WELWYN HATFIELD BOROUGH COUNCIL – DEVELOPMENT MANAGEMENT
DELEGATED REPORT

APPLICATION No: S6/2014/1091/FP

SITE ADDRESS: Oak Cottage Residential Home, 4 Wilkins Green Lane, Hatfield

DESCRIPTION OF DEVELOPMENT: Erection of a rear extension

TITLE Proposed Elevations North & South	
PROJECT NAME Oak Cottage, 4 Wilkins Green Lane, Hatfield, AL10 9RT	
DRAWN BY	DATE MARCH 2014
SCALE 1:100 @ A3	CHECKED
DRAWING NO. EL/2012/07	REV. NO. G

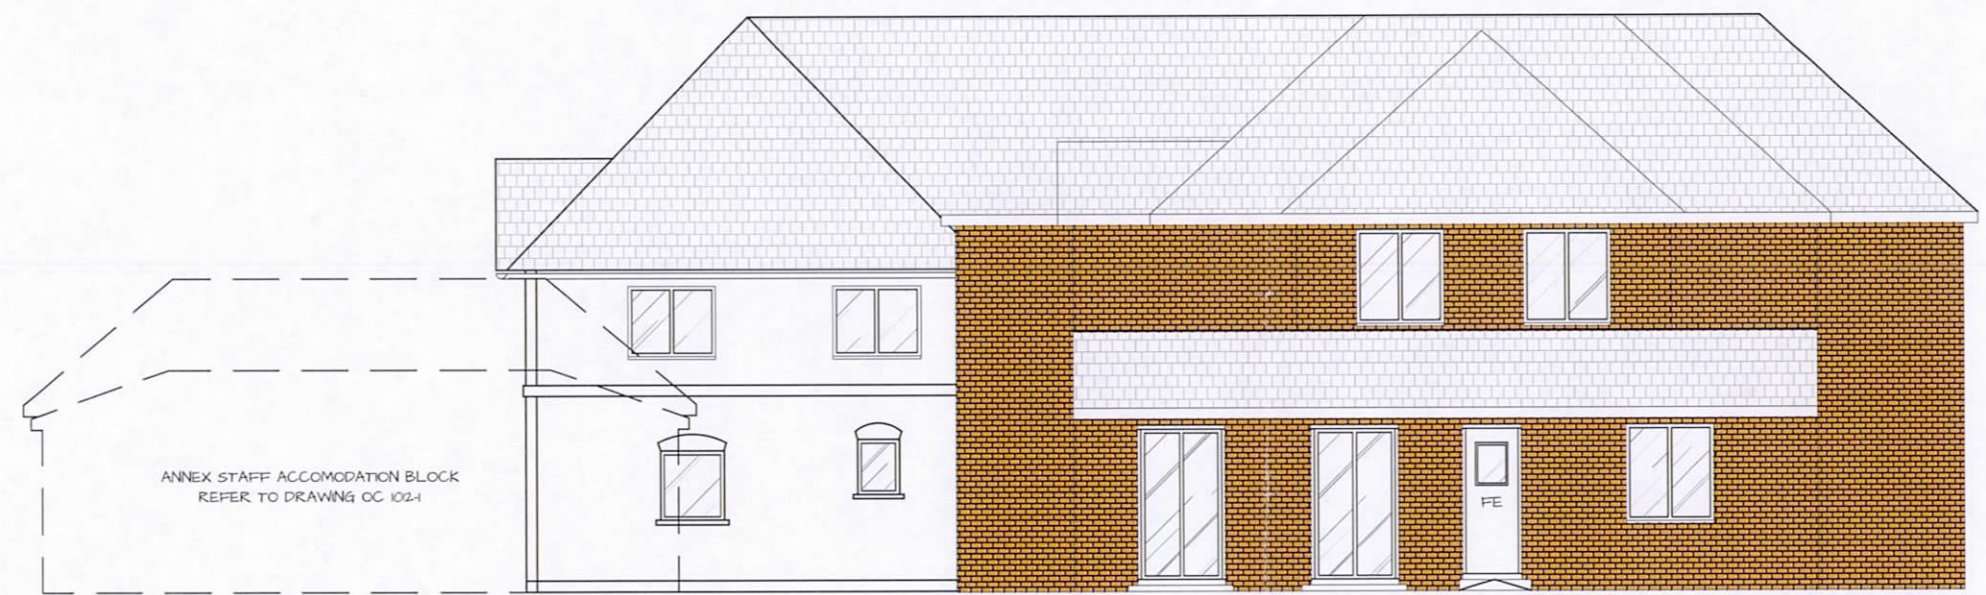
The depth of the original building measured approximately 9.9m along its west elevation. Cumulatively, this proposal would result in a rear extension measuring 17.1m, increasing the total depth of the building to 27m. This is a substantial increase by any measure and when considered cumulatively with the existing extensions, the proposed development would fail to remain subordinate in scale to the original building. The apparent size of the extension would be accentuated by its bulky and poorly proportioned design. In visual terms, whilst the extension is set in from the flank wall of the original building, there is very little articulation along its length to break up its bulk and massing. Some attempt has been made to reduce the scale of the first floor and roof by setting it in 500mm across the rear and by adding a gable element, however, the benefits of these elements is limited given the overall scale of the extension. In terms of quality of design, these features would appear crude and contrived given that the gable feature would be flanked by flat roofs at first floor level and the pitch of the lean to roof would not match the main roof.

Two first floor windows serving a bedroom are proposed within the rear elevation of the proposed extension. Whilst there are windows to the rear of the existing extension, the new windows would be a further 7.5m into the plot and therefore more intrusive into the gardens of neighbouring properties, particularly No.5 Wilkins Green Lane. Three new windows are proposed at first floor level within the west elevation, facing the common boundary with No.5, however, the potential for additional overlooking from these windows is limited as one would be a high level window serving an office, one would serve a landing and one would serve an en-suite (shown as obscure glass). Whilst the degree of potential overlooking from the proposed first floor windows towards No.5 would be limited in this proposal, it is also relevant to consider the impact of the windows in terms of a perceived increase in overlooking. The existing and proposed extension would result in a total of five windows at first floor level facing No.5 and extending deep into the garden of this property which would result in a conspicuous presence that would spoil the neighbouring occupiers' reasonable enjoyment of their property.

TITLE Proposed Elevations North East & West	
PROJECT NAME Oak Cottage, 4 Wilkins Green Lane, Hatfield, AL10 9RT	
DRAWN BY	DATE MARCH 2014
SCALE 1:100 @ A3	CHECKED
DRAWING NO. EL/2012/08	REV. NO. G

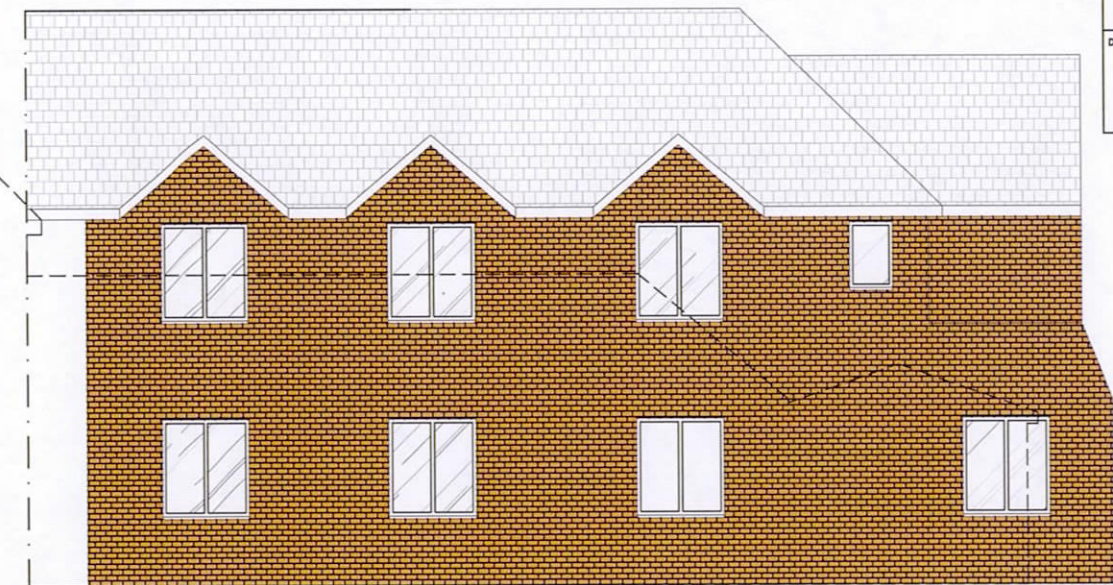
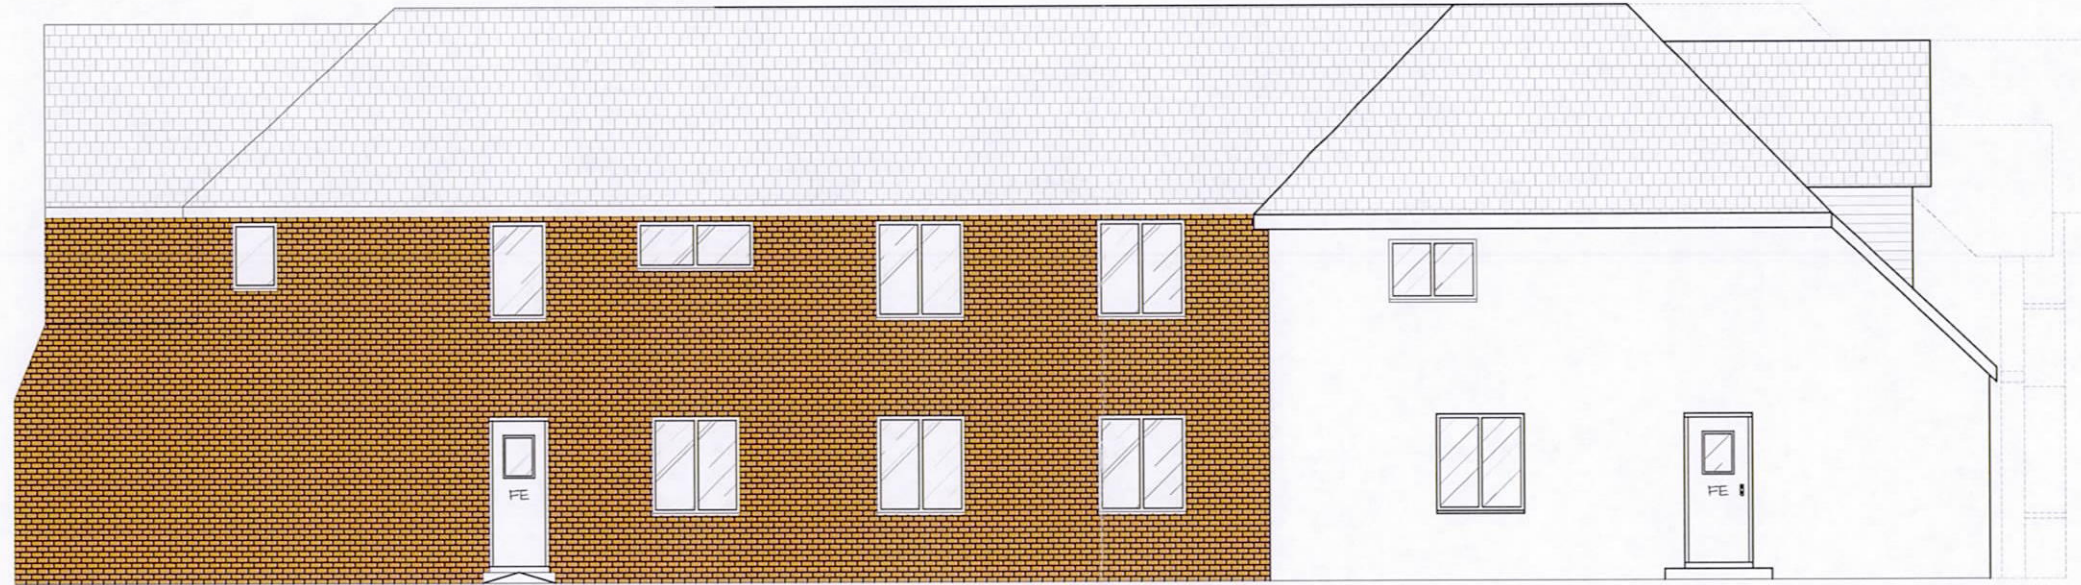
Turning to the east elevation, it is proposed to add approximately 1.3m to the width of the existing extension and infill the area between the proposed extension and the original building. This part of the proposal would also be covered with sections of flat roof as well as three gable elements.

The existing building is characterised by a hipped roof with feature gables above some windows. Whilst there is a section of flat roof in a corner between the main dwelling and the rear extension, this is a small infill area which is well concealed. More importantly, its existence does not demonstrate that this type of development is worthy of repetition, in fact quite the opposite. Repetition of this type of development would fail to respect or relate to the original building and would have a deleterious effect on its character and appearance.

The proposed first floor windows to the eastern side of the building would have a greater separation from the side boundary of the plot and so the potential for overlooking is reduced for the adjoining neighbour at No.3. Notwithstanding this, the development would still impact upon the privacy of the rear garden of No.3 as a result of three new first floor windows that would face east towards No.3. Two of these windows would serve resident bedrooms (Room 13 & 14) and one would serve an en-suite (obscure glazed). In total, four first floor windows within the extension would face the common boundary with No.3, which would result in an unacceptable degree of perceived overlooking to the neighbouring occupiers.

<b>TITLE</b> Proposed Ground & First Floor Plan	
<b>PROJECT NAME</b> Oak Cottage, 4 Wilkins Green Lane, Hatfield, AL10 9RT	
<b>DRAWN BY</b> E.B	<b>DATE</b> MARCH 2014
<b>SCALE</b> 1:100 @ A1	<b>CHECKED</b>
<b>DRAWING NO.</b> EL/2012/05	<b>REV. NO.</b> G

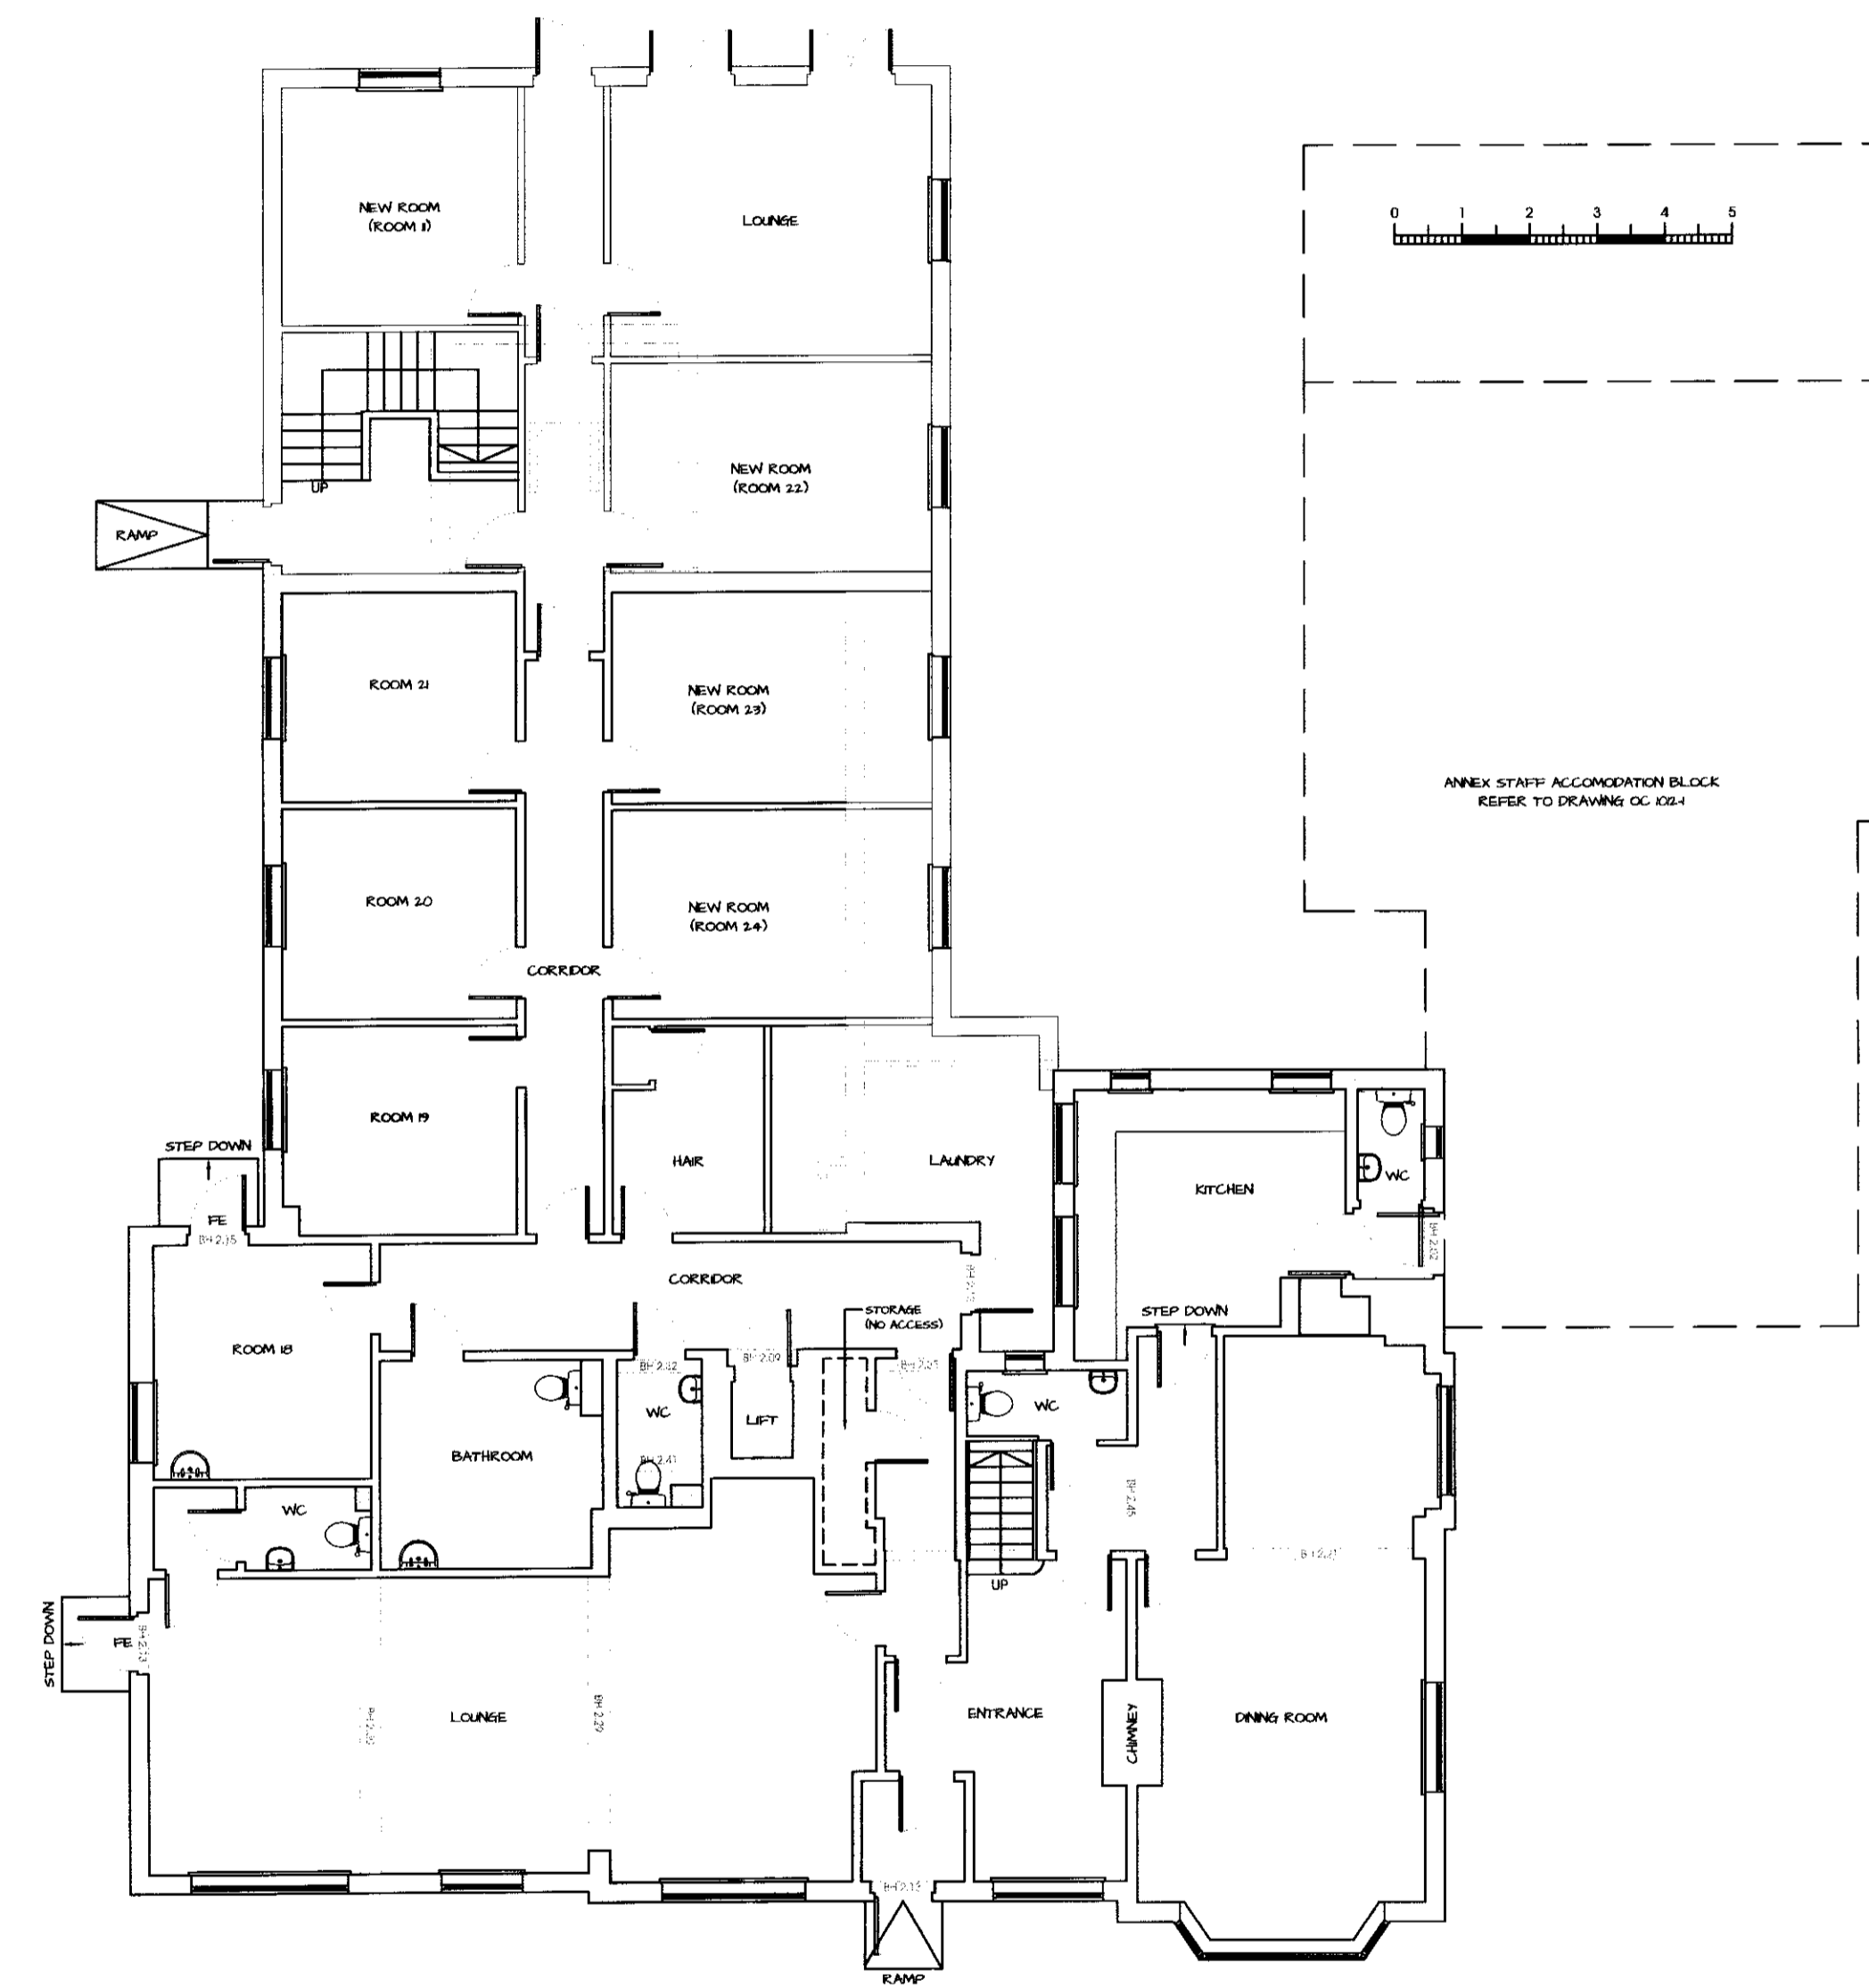
This proposal would add a further substantial increase the size of the existing building and, in particular, the depth of the building. The footprint of the proposal would measure approximately 7.5m in depth x 10.2m in width and would wrap around the rear and east side of the existing rear extension. The resulting extension would project approximately 4m further than the existing extension (part of which is to be demolished) and approximately 1.3m would be added to the width of the existing rear extension. A further first floor extension would infill the area between the proposed rear extension and the original dwelling.
